**WELWYN HATFIELD BOROUGH COUNCIL
ASSISTANT DIRECTOR (PLANNING)**

DELEGATED APPLICATION

Application No: 6/2023/2285/FULL
Location: 61 Tiger Moth Way Hatfield AL10 9LT
Proposal: Retention of change of use from HMO to C2 dwelling
Officer: Ms Ashley Ransome

Recommendation: Refused

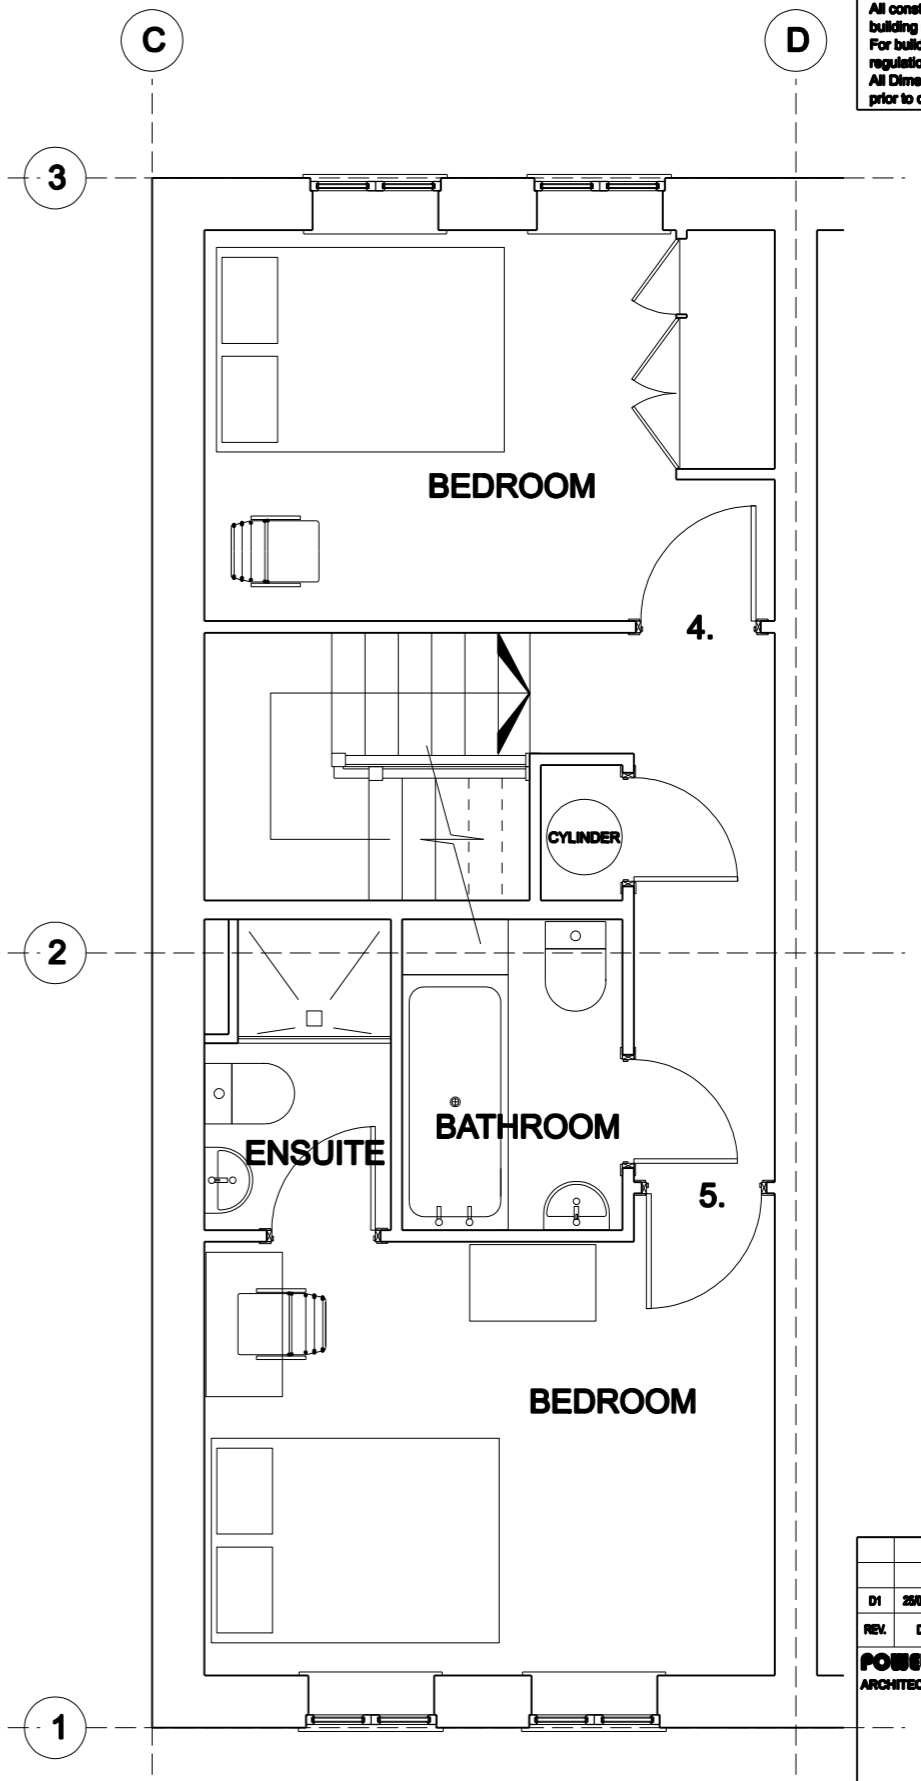
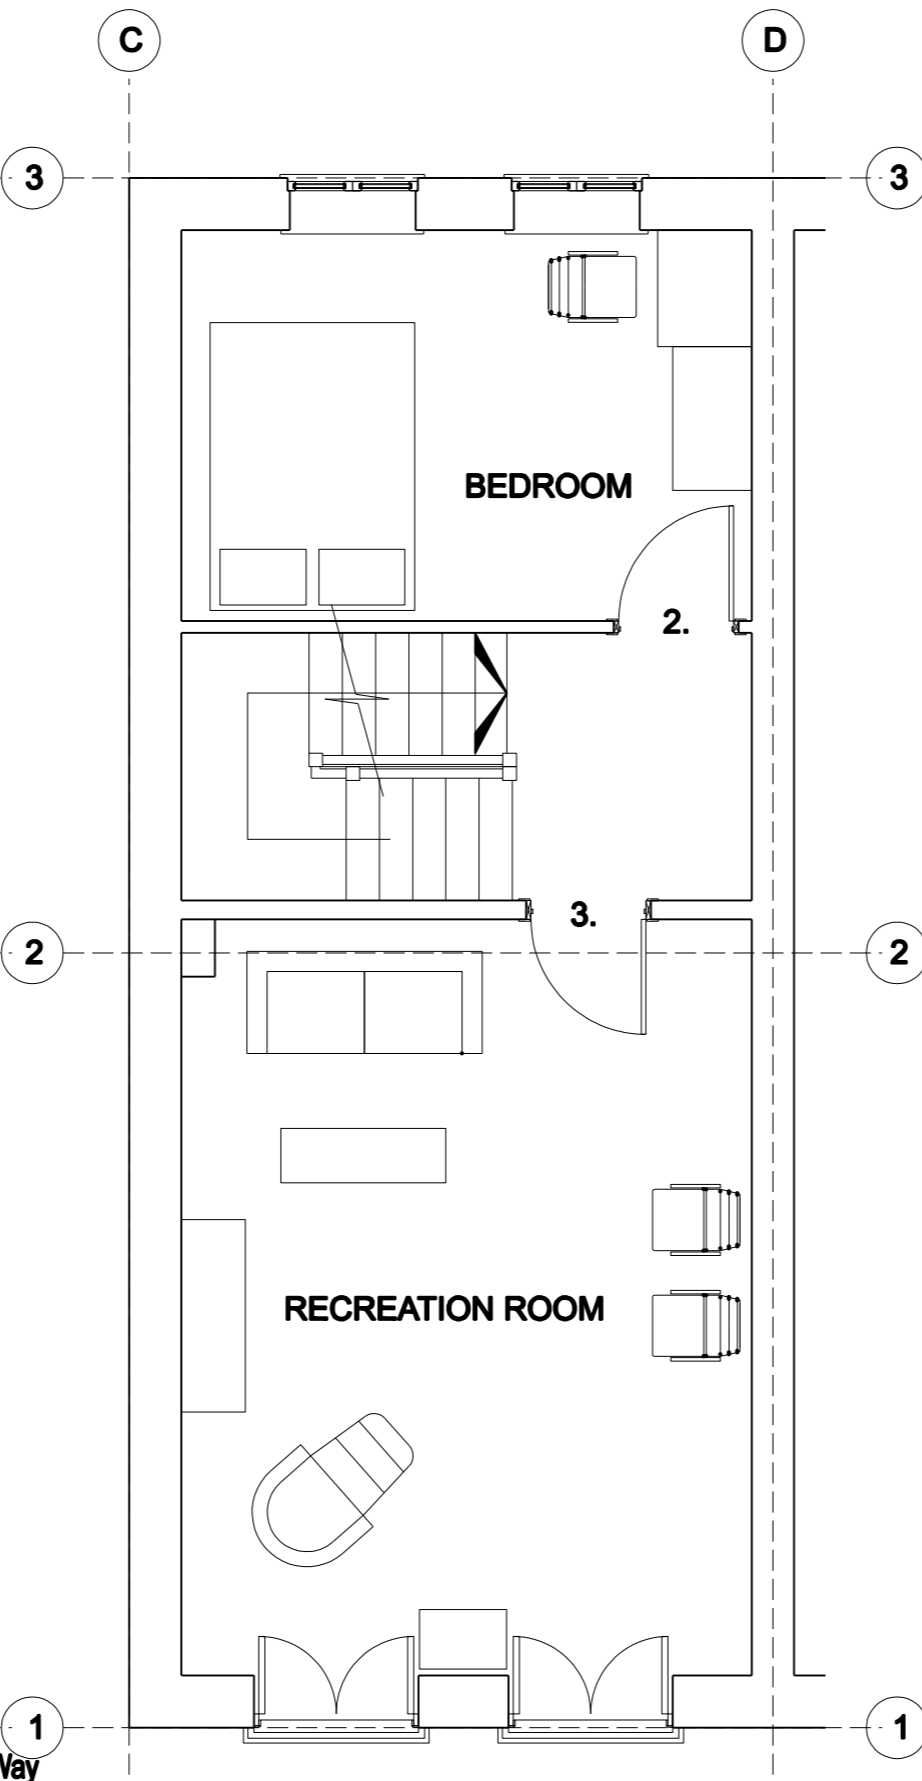
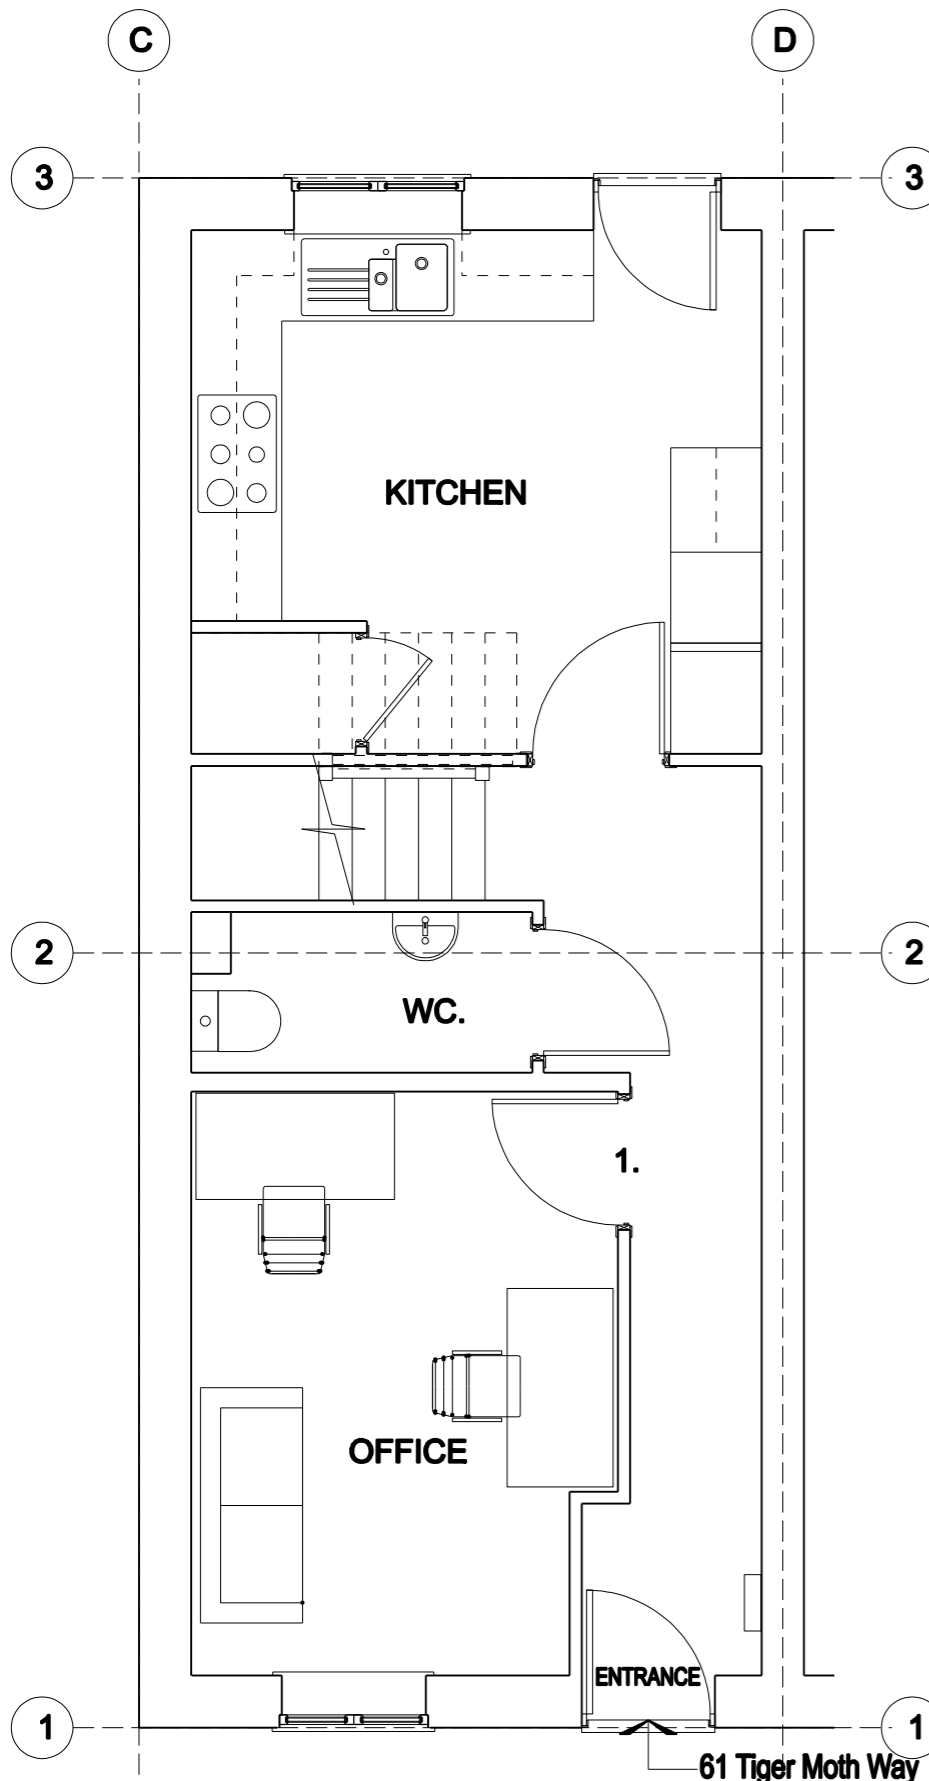
<p>for dwellings. If a dwelling has more than one bedroom, Table 1 of the NDSS suggests the minimum number of bed spaces (persons) is 3 people (one double room and one single).</p> <p>The Nationally Described Space Standards sets out that the floor space of a double bedroom should measure 11.5m². From observing and measuring the submitted floor plans, two of the bedrooms (one on the first floor and one on the second floor) do not meet the Nationally Described Space Standards for a double bedroom. It is however acknowledged that these bedrooms remain as existing, along with the consideration that the proposal would not be for dwelling use and thus the standards are therefore only guidance. Moreover, the bedrooms would likely be for a single occupant due to the nature of the proposed use as a residential institution, and if planning permission were granted, the number of occupants could be controlled by condition such that the rooms would be single occupancy only. It is therefore considered that this would not be a reasonable reason to form the refusal of the application.</p> <p>In terms of private amenity space, Policy SADM11 of the District Plan and the Supplementary Design Guidance requires all residential development to incorporate private amenity space for the use of residents. The Council does not apply rigid standard sizes for gardens, but the layout and design of the garden in relation to the built environment should ensure that the garden is functional and useable in terms of its orientation, width, depth and shape, with the garden large enough to be useable and meet the needs of the occupiers of the home. The property benefits from a garden to the rear. Whilst the garden is small, it would provide an adequate outdoor amenity space given the level of occupancy proposed and the large areas of public open space nearby.</p>

**01** PROPOSED BLOCK PLAN  
 SCALE 1:500

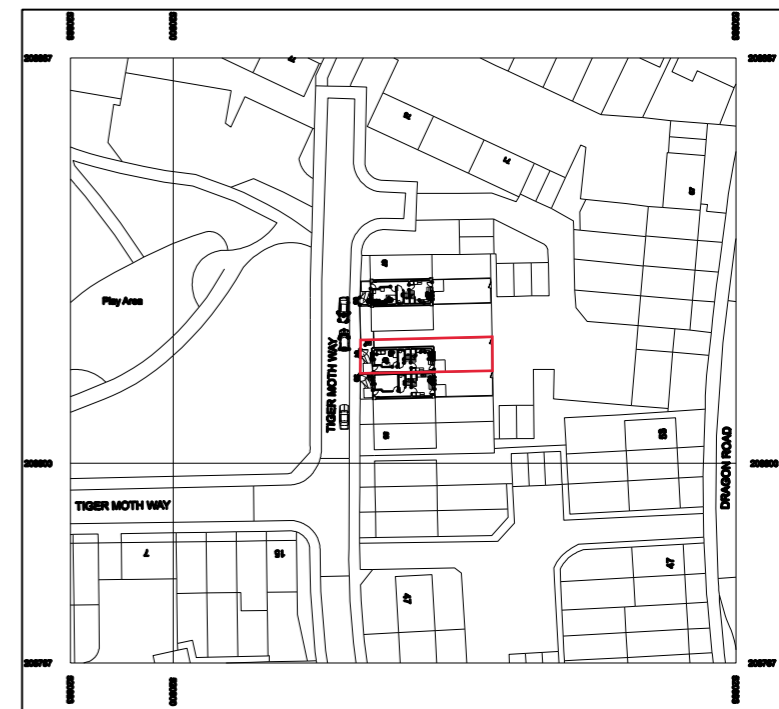
No details have been provided with respect to the current parking arrangements for occupants or visitors to the site. The application form states that there is no off-street parking and the red line boundary on the location plan solely encompasses the site only, with no off-street parking being included within the red line. The application is therefore assessed on the basis that no off-street parking currently exists for the site.
